Your reference: SSD-70316465
Our reference: DA20240506001806-Response to
Submissions-1

Date: Tuesday 27 January 2026

**State Significant Development – Response to Submissions – Warehouse or Distribution Centre
Burrah Park - SSD-70316465 - 1953-2109 Elizabeth Drive Badgerys Creek NSW 2555, 1//DP1306448**

In accordance with PBP the predominant vegetation class has been determined for a distance of at least 140 m out from the proposed lots. There are three vegetation structural formations that may present a bushfire hazard to the proposed development as listed below and mapped on Figure 5.

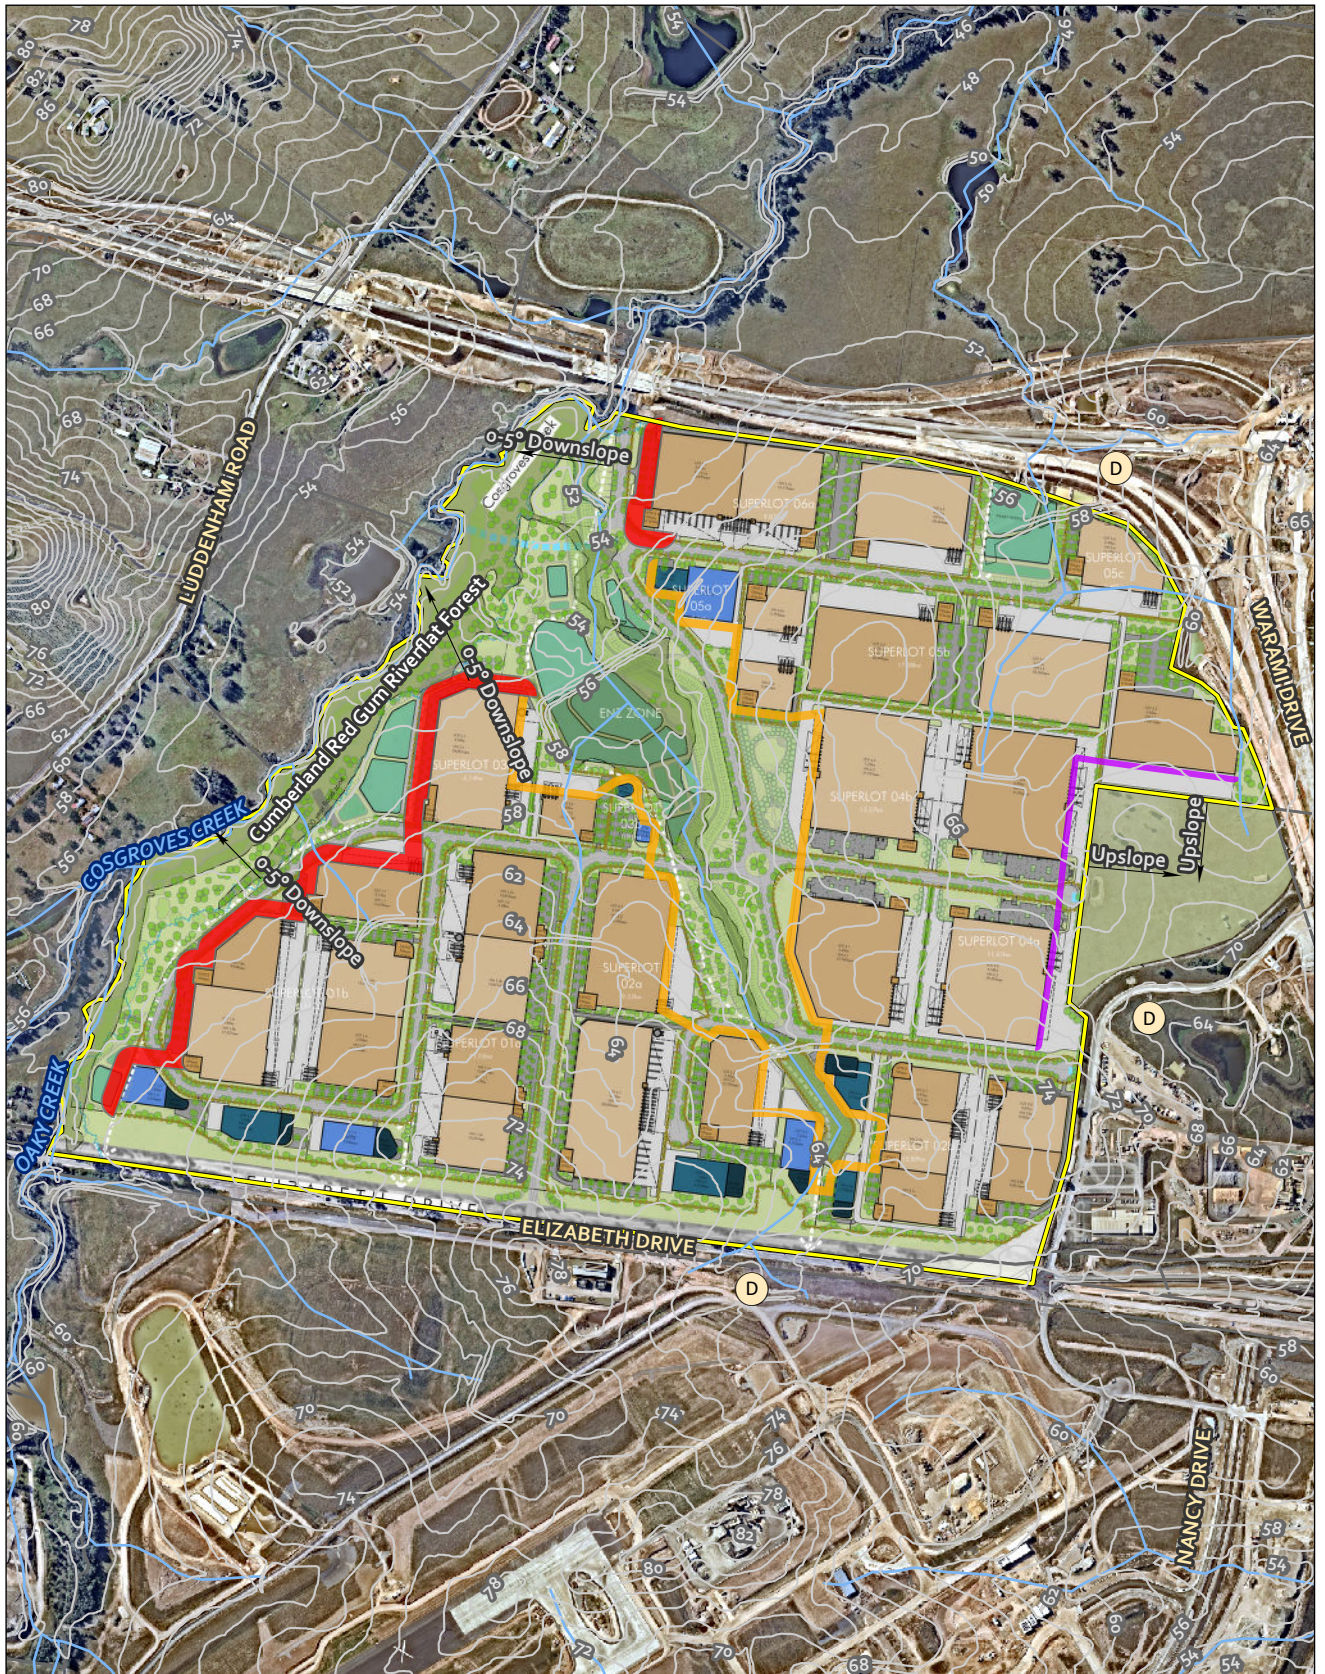
1. At the commencement of building works or the issue of a subdivision certificate, whichever comes first, the area identified in Figure 5 of the document titled *Bushfire Assessment - Burrah Park Concept & Stage 1*, prepared by Peterson Bushfire, Ref: 24050, dated 12 November 2025 must be maintained as an inner protection area in accordance with the requirements of Appendix 4 of *Planning for Bush Fire Protection 2019*.
